Mr Campbell Dungan
Bursar
THE COUNCIL OF TRINITY GRAMMAR SCHOOL
TRINITY GRAMMAR SCHOOL 119
PROSPECT ROAD
SUMMER HILL 2130
11/12/2020

Trinity Grammar School Redevelopment (SSD-10371)
Request for Additional Information

I refer to Response to Submissions (RtS) for the Trinity Grammar School Redevelopment (SSD-10371). After careful consideration, the Department is requesting that you provide additional information as follows:

Figure 6 - Jubilee car park future layout

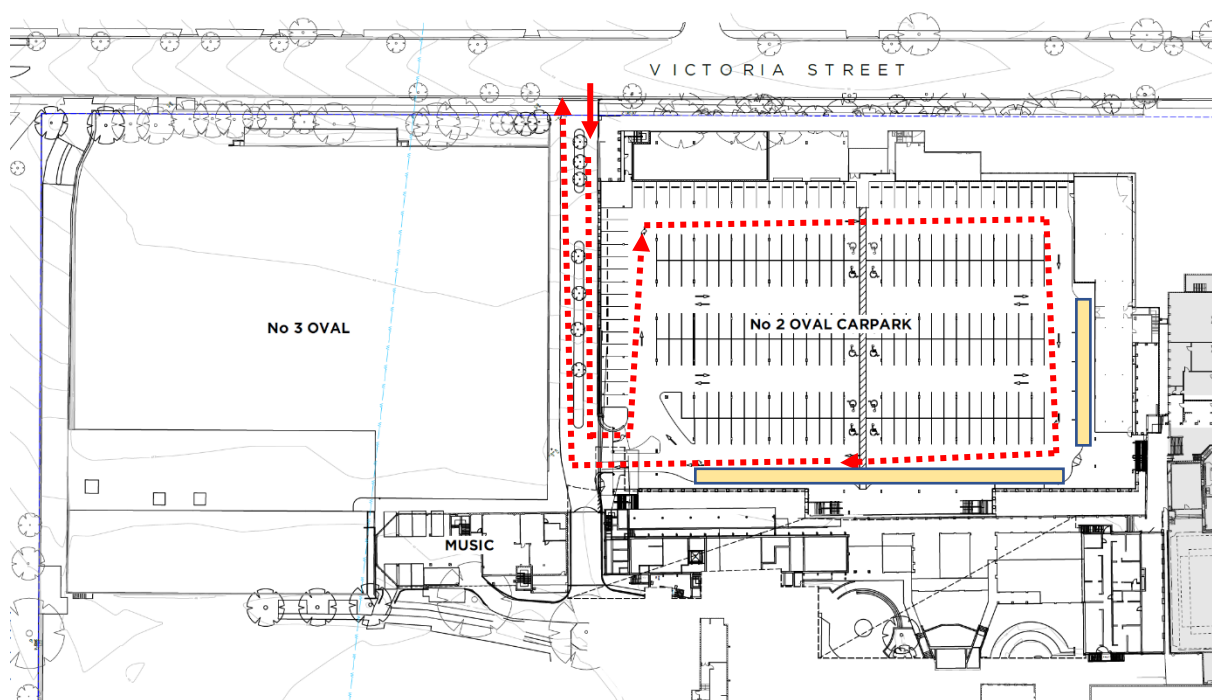
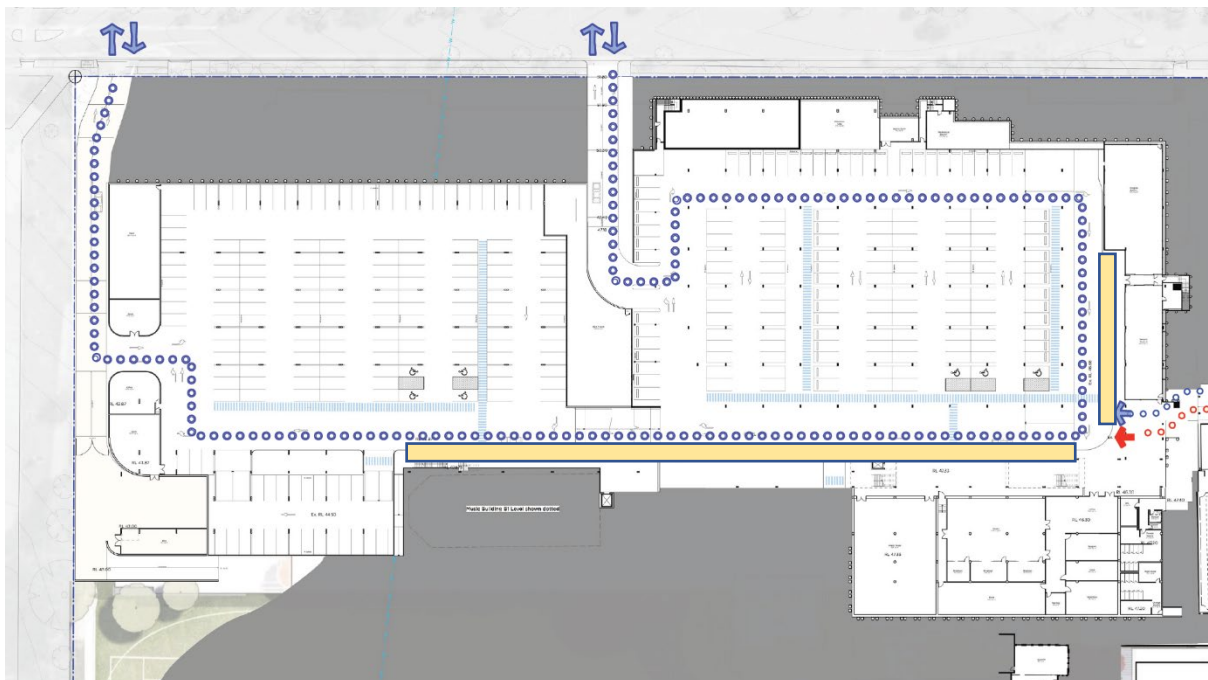
The Department requests additional information be provided to understand the capacity and demand of the pick-up and drop off area. In this regard the Department notes that the analysis provided with the RtS indicates that under both the existing and the proposed arrangements the pickup/drop off would operate below capacity. However, the Department requires more information to substantiate the assessment as from the details provided in the public submissions and having regard to the previous findings of the NSW Land and Environment Court case (*Council of Trinity Grammar School v Ashfield Council [2015] NSWLEC 1086*), it appears likely that the current arrangements cannot accommodate the current demand, contrary to the information provided in the RtS. Therefore, the Department requires:

- a) detailed information based on surveys and data collection to demonstrate how the existing and proposed demand has been calculated. The Department notes the number of vehicle trips is very different from data provided in the original traffic assessment, and the increase in demand (82 AM trips and 45 PM trips) is inconsistent with the traffic assessment which provides that the proposal would generate an additional 196 student vehicle trips in both of the peaks, the vast majority of which would be pick-ups / drop offs.
- b) detailed information to demonstrate demand in the 20 minutes immediately before the AM bell and 20 minutes immediately after the PM bell, noting that peak demand is not spread over an hour but is usually concentrated over a very short timeframe. Where demand results in queuing on Victoria Street, an analysis should

be provided of any change in queue lengths and time frame for the on-street queue to clear as a result of the revised design and increased student numbers.

- c) consideration of impacts on queue lengths as a result of other vehicles accessing the site to park.

Figure 7 – Intersections reviewed

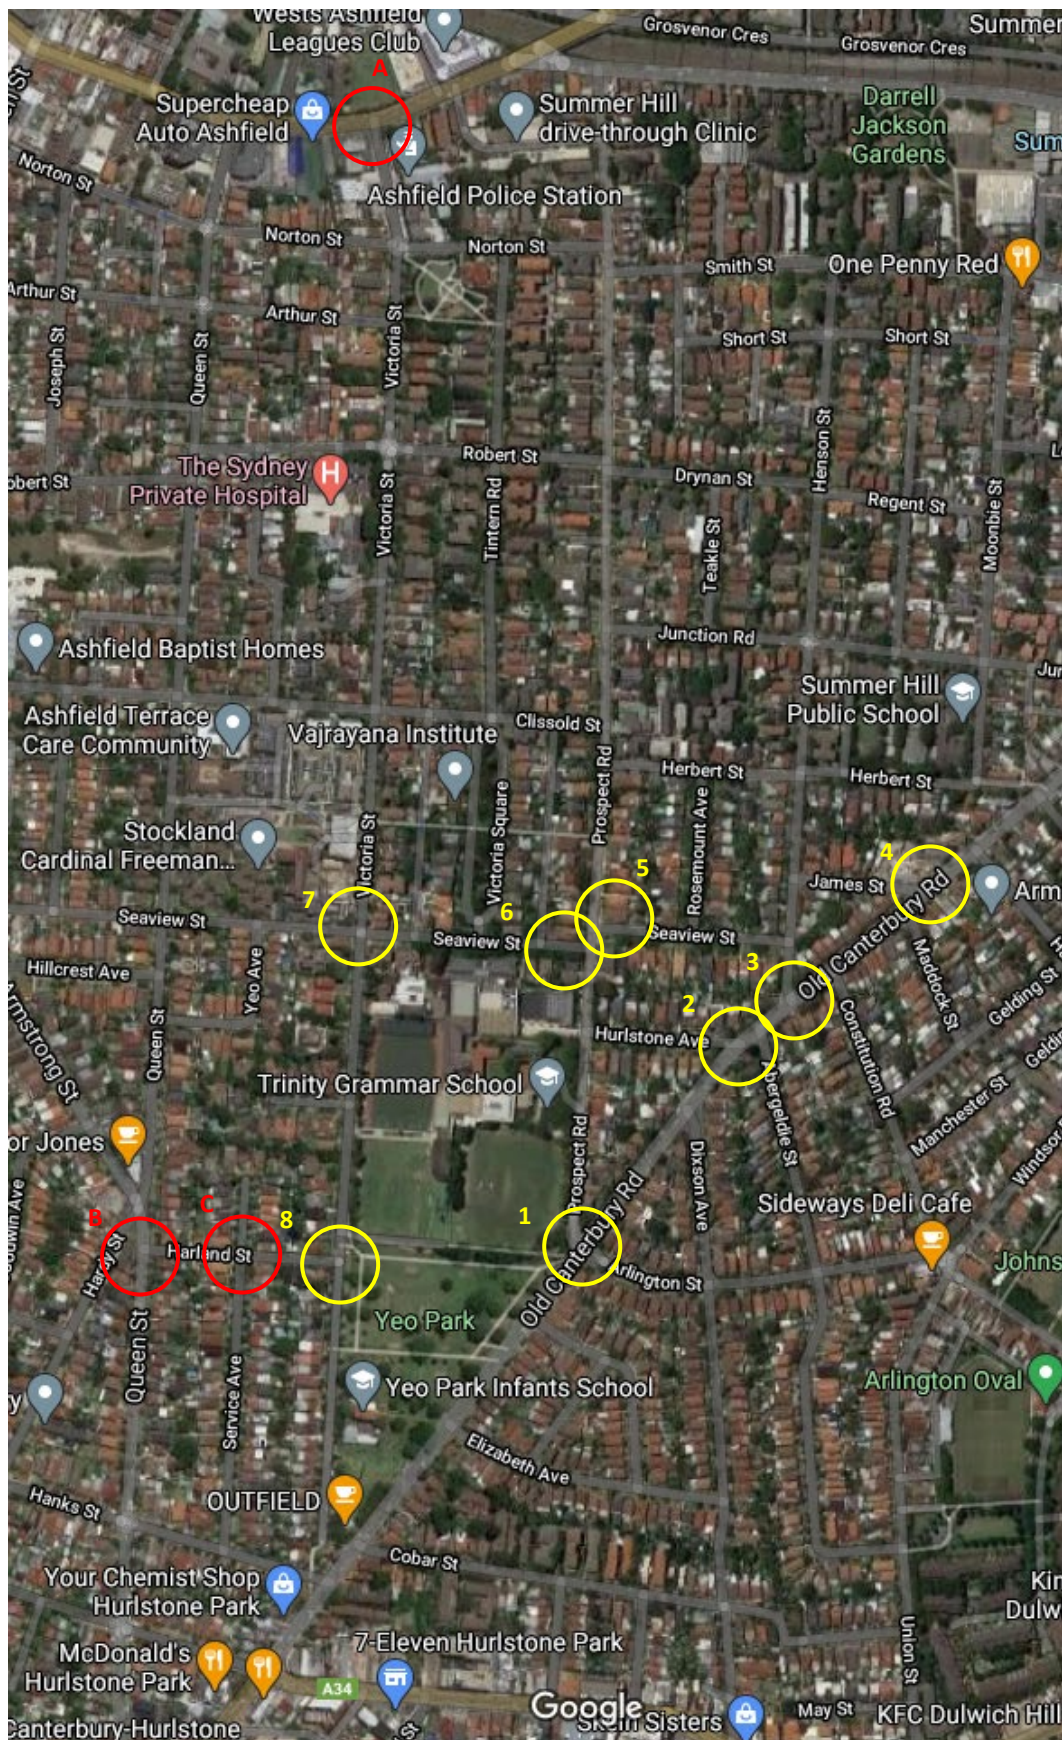
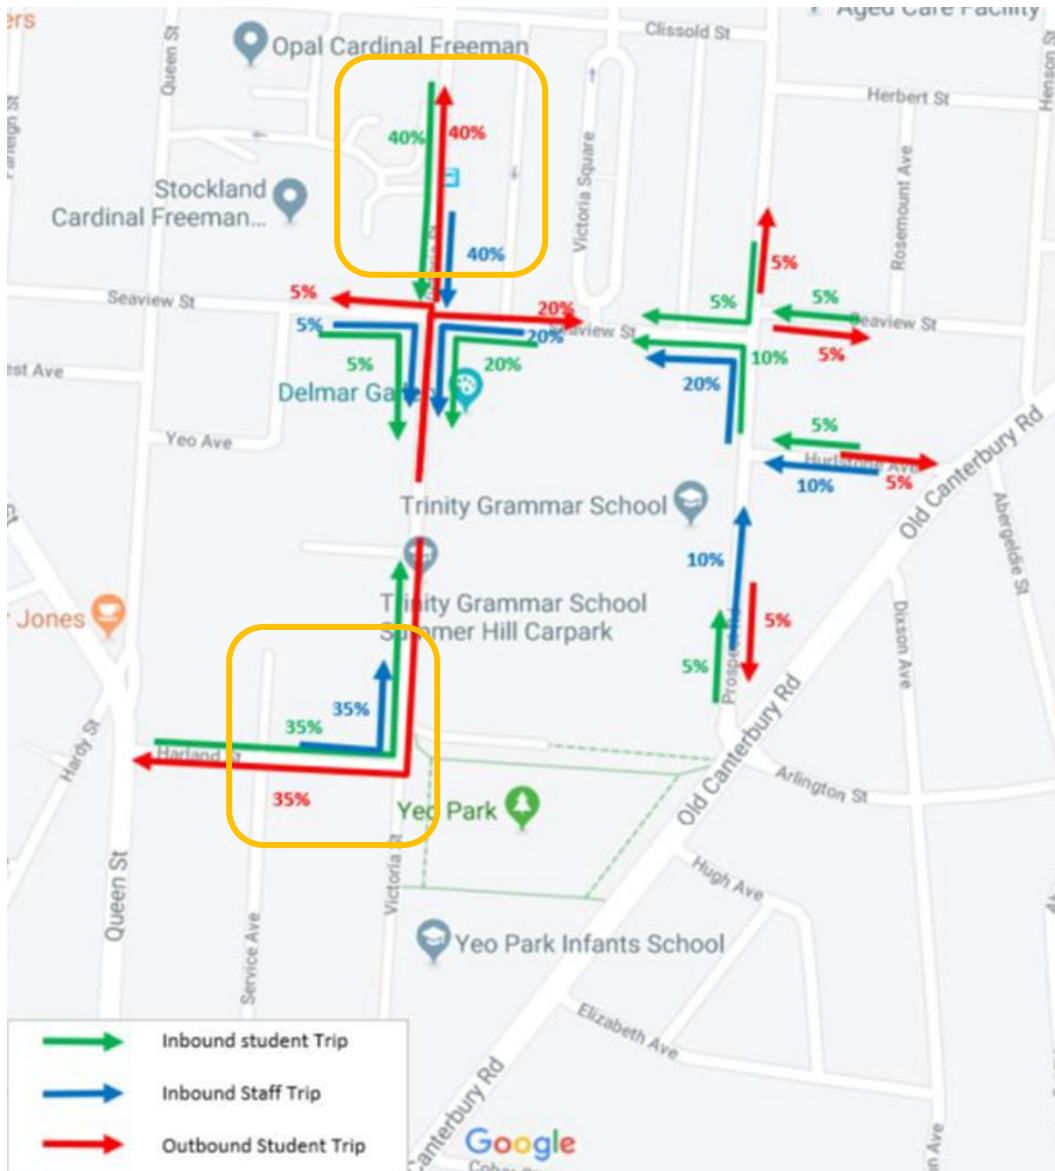
The traffic assessment indicates that the majority of vehicle trips associated with the school use would travel either via Queen Street / Harland Street or Victoria Street / Liverpool Road, however no assessment has been provided of the impacts of the proposal on these intersections. Therefore, the Department requests that:

- a) further traffic assessment of the impacts to the operation of these intersections be provided,
- b) further assessment of the impacts to the operation of the intersection of Harland Street / Service Avenue.

Additionally, the analysis should compare the situation between a current lawful operation of the school (1500 students) vs the proposal for 2100 students. Where appropriate, consideration should be given to any mitigation measures to offset the traffic impacts of the proposal.
